**My reference FS-Case_545314089 Objection to Planning Application 2023/92230
Collingwood 5a Greenway, Honley**

The wording of the 2023 application for the extension and alterations to 5a Greenway is misleading. Several neighbours who have received a letter from Kirklees or have seen the application attached to the nearby lamppost have assumed on reading “*Erection of **single storey rear extension** and raise height of roof and walls...etc.*” have not realised that this is actually an application to extend the bungalow into a full two-storey house.

Side Elevation W
1 : 100

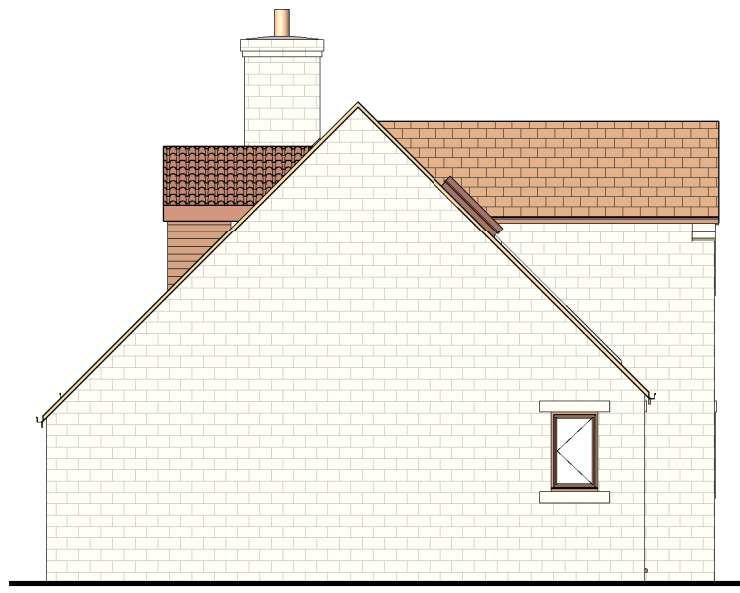
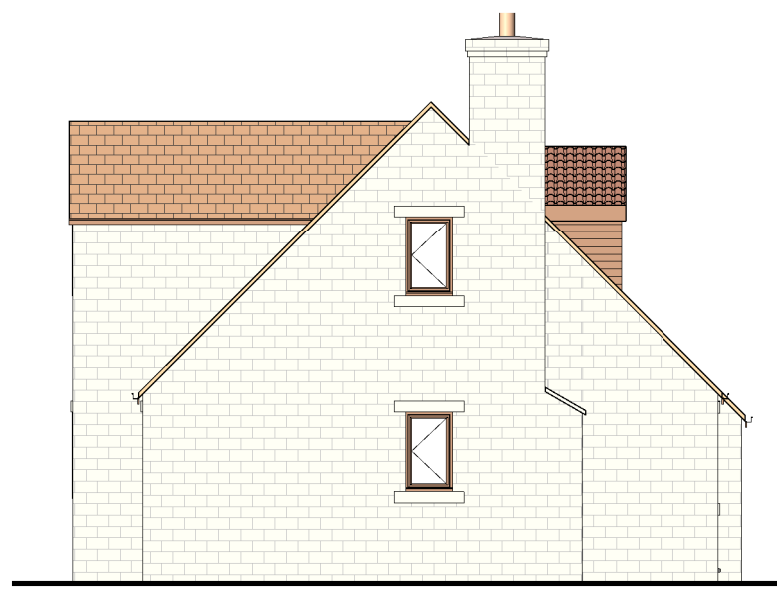
- The proposed tall building with its raised roof and two-storey walls would be an oppressive addition to the street scene. I do not feel that it is obvious from the plans just how tall and narrow the current bungalow is, and query the accuracy of the drawing as it shows the jutting out section as less steep than it actually is. The current proposal to create a two-storey house with a roof raised even higher (I can't see any measurements showing how much higher) and large wide two-storey size walls and raised wider roof, changes a diminutive dormer bungalow into an overpowering building which will dominate the entrance to the court, and will significantly and negatively impact the appearance and feel of spaciousness on Greenlea Court.

- Please note that the current window does not look into the landing window. Nor does it look down into the garden of 7 Greenway, and the clerestory window in the roof cannot look into the garden of no 7. If a two-storey house is built the windows will look directly down into the garden of 7 Greenway.

- I also understand that any upper floor window on a side elevation which overlook another property must be obscure-glazed and non-opening unless situated 1.7 metres above the floor in a house within a conservation area, this is not indicated on the plans. I think it is probable that the new window in the side extension of 5a will overlook the kitchen extension and back garden of 5 Greenway.

Rear Elevation S
1 : 100

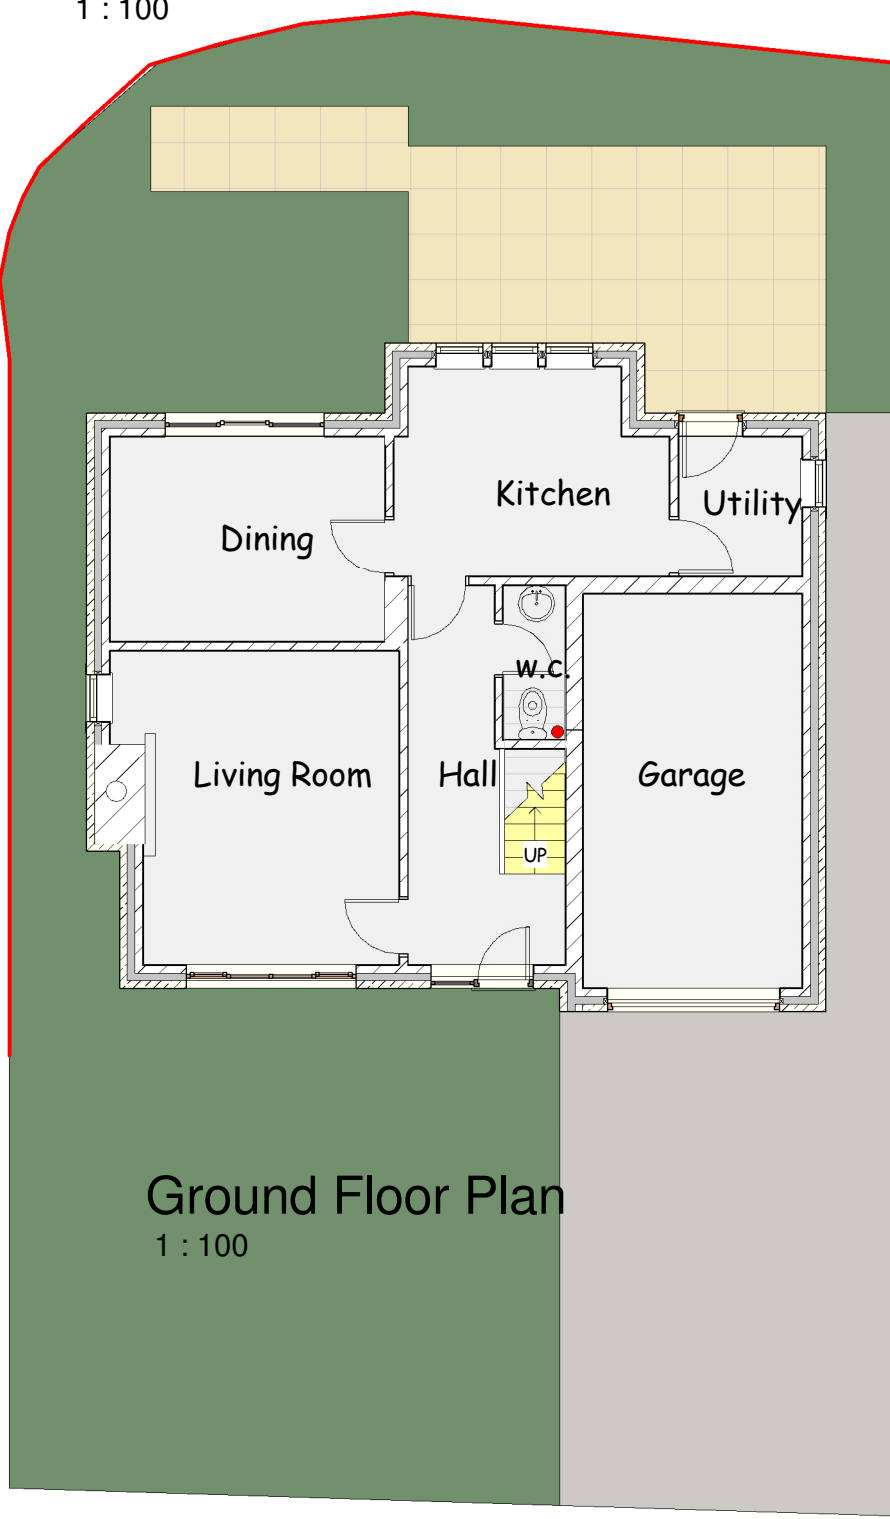
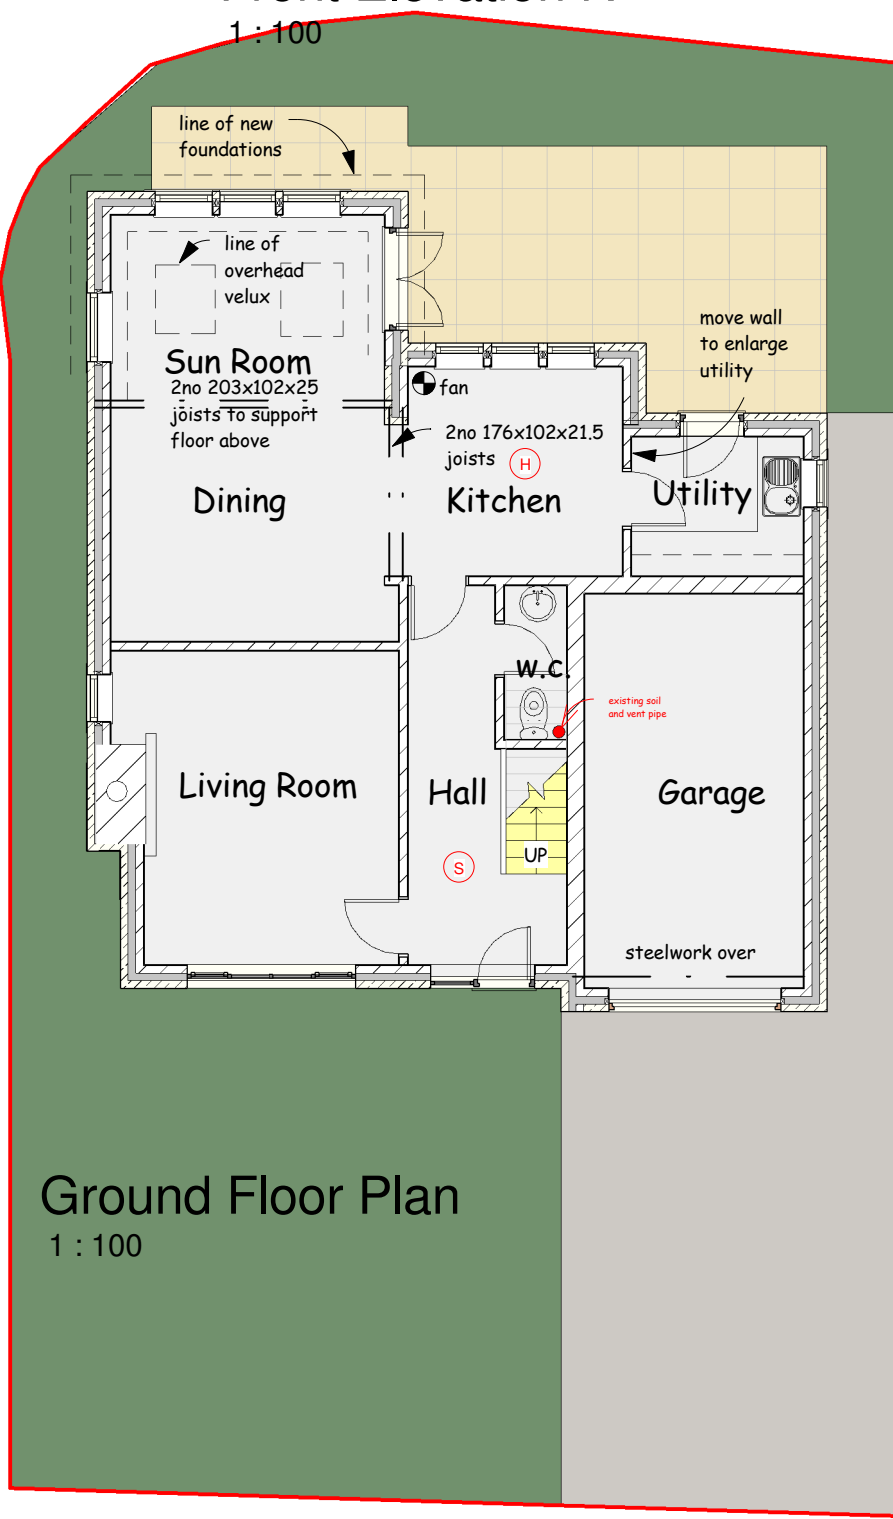
- **The extension is not subservient to the original building**, the proposed extension is to expand the whole of the original building in both width and height by raising the roof level (rather than keeping any extension lower than the original ridge line as set out in Kirklees guidelines) and creating a two-storey house. It is by no means in character with the host property in fact seeks to change it totally. The two-storey house will dominate the upper end of the cul de sac especially when viewed from 4 Greenlea Court (photo attached) which is down the slope from 5a Greenway

- The plan is now for a two storey extension creating a full-size house, but by raising roof and putting in two bedroom windows, the rear upstairs window will overlook property 4, looking down into the lounge and directly across into our landing and front bedroom

- **The upstairs window above the lounge will look directly across into the front bedroom window and into the landing window of 4 Greenlea Court. It is an open gallery landing so that all the bedroom doors can be seen and passage to the bathroom clearly viewed.**

Ground Floor Plan
1 : 100

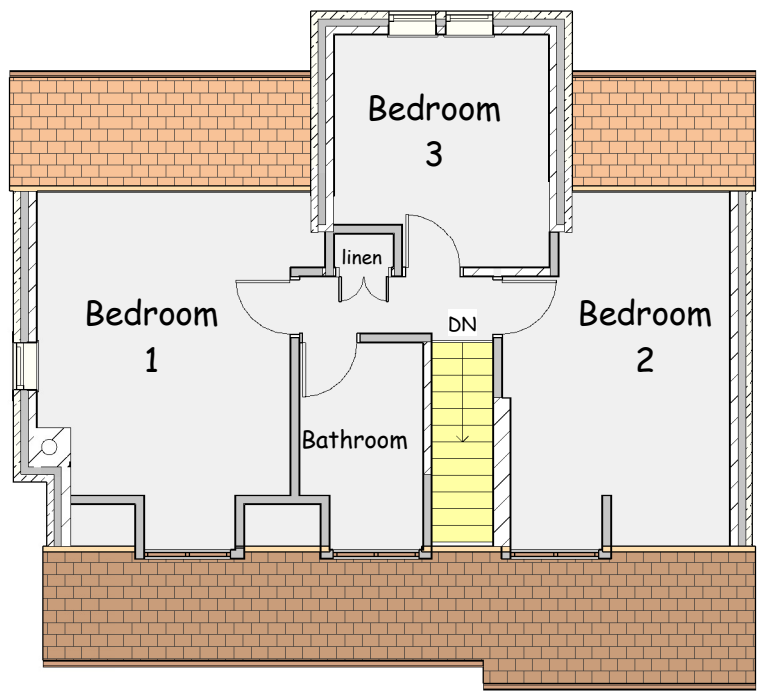
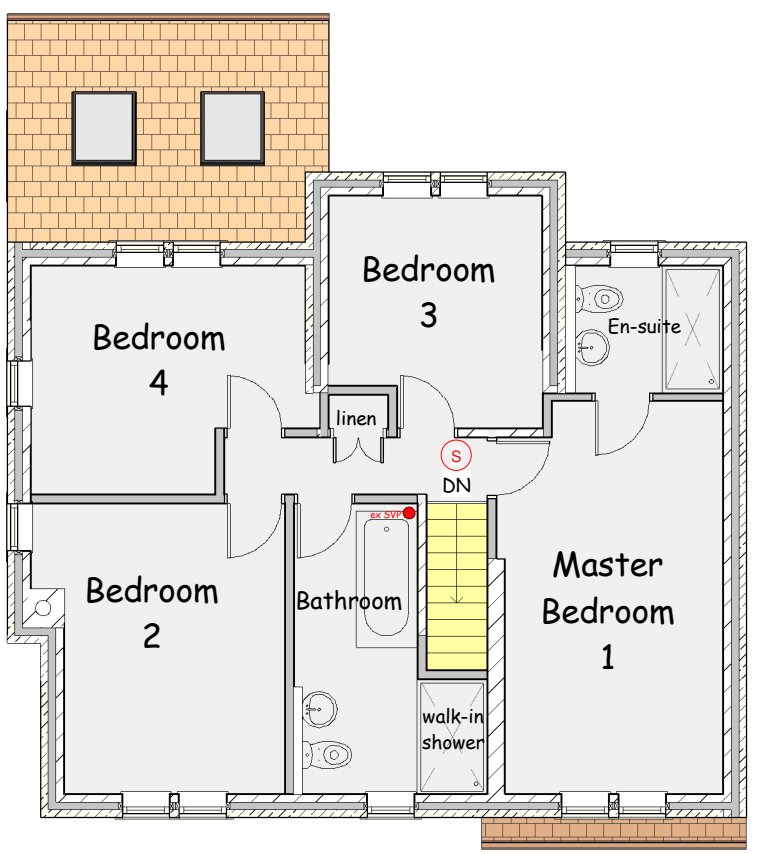
- I understand that an overlooking window should not be built into any extension within 21 metres of another house anyway but as no measurement or ground plans are shown this is impossible for me to work out accurately.

- With regard to the proportion of house to garden: I question the statement that 'the scale of the revised proposal is very similar to others houses that exist in the area' – the other houses have decent size gardens to match and are not perched on a tiny plot of land. The garden of no 5a Greenway is totally out of proportion to what would be usual for a good-sized 4 bedroom house, and the house if made any taller it will appear more like a town house with very little land around it.
- If some of the front garden is altered to provide parking space for extra cars, and a large proportion of the garden at the rear of the property is built on for the extension of the sun room, I question whether half of the garden will be retained, but in view of the lack of a ground plan this is difficult to ascertain.
